STATE OF WASHINGTON
DEPARTMENT OF ECOLOGY

Thank you for the opportunity to comment on the short plat of approximately 50.00 acres into 4 lots, proposed by Luther Parker and Todd Parker [SP-09-00002]. We have reviewed the application and have the following comments.

MEMORANDUM

TO: Allison Kimball, Community Development Services
FROM: Christina Wollman, Planner II *CW*
DATE: March 10, 2009
SUBJECT: Sage Land Short Plat SP-09-00002

# SAGE LAND SHORT PLAT - K.C.S.P. #09-?????

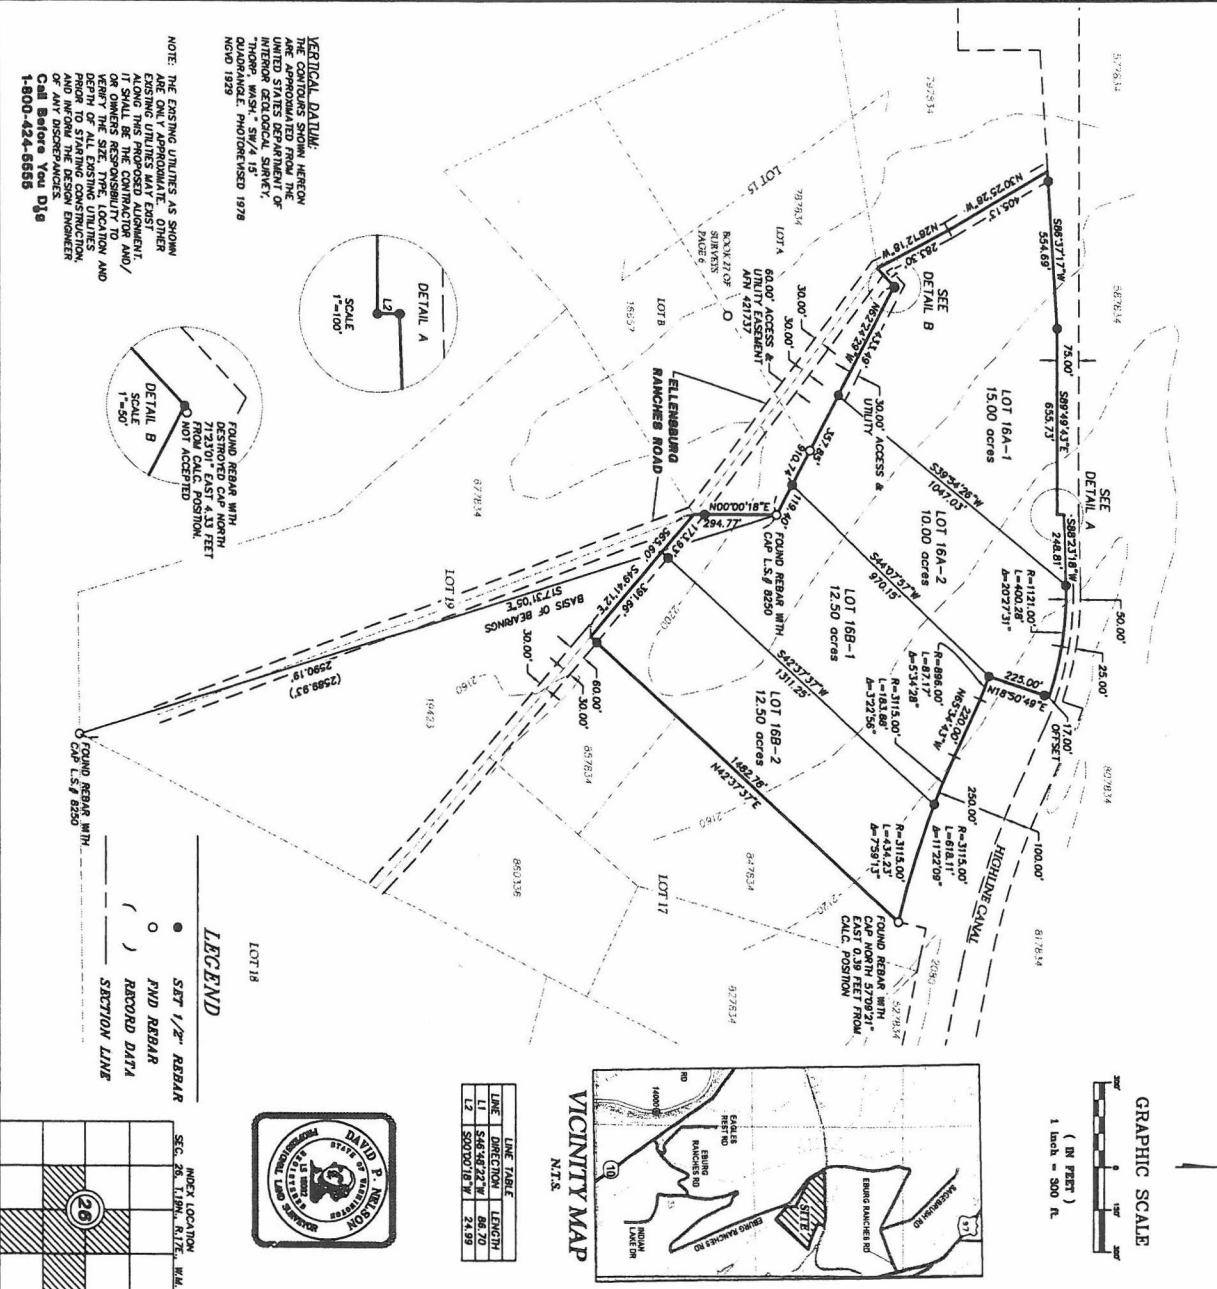
2. Ellensburg Ranches Road Private Road Improvements: Ellensburg Ranches Road shall be improved from either US 97 or SR 10 to the final access into the property to meet or exceed the Low-Density Private Road standard (per current Kittitas County Road Standards).

- a. Access easements shall be a minimum of 60'. The roadway shall have a minimum width of 20', with 1' shoulders, for a total width of 22'.
 - b. Minimum centerline radius will be 60'.

- c. Surface requirement 6" gravel surface.
 - d. Maximum grade is 12%.
 - e. Stopping site distance, reference AASHTO.
 - f. Entering site distance, reference AASHTO.

- j. All easements shall provide for AASHTO radius at the intersection with a County Road.
5. Turnaround: Ellensburg Ranches Road requires a turnaround. A hammerhead turnaround may be constructed in lieu of a cul-de-sac. Additional easement may be required. Turnaround locations shall be shown on the plat. Hammerheads must be constructed as specified in the 2006 International Fire Code. Cul-de-sac requirements are shown below.

6. Cul-de-Sac: A cul-de-sac turn-around having an outside right-of-way easement diameter of at least 110 feet shall be constructed at the closed end of all dead-end roads serving 3 or more lots. The driving surface shall be at least 96 feet in diameter. Cul-de-sacs must also conform to the requirements specified by the 2006 International Fire Code. Contact the Fire Marshal regarding any additional cul-de-sac requirements.
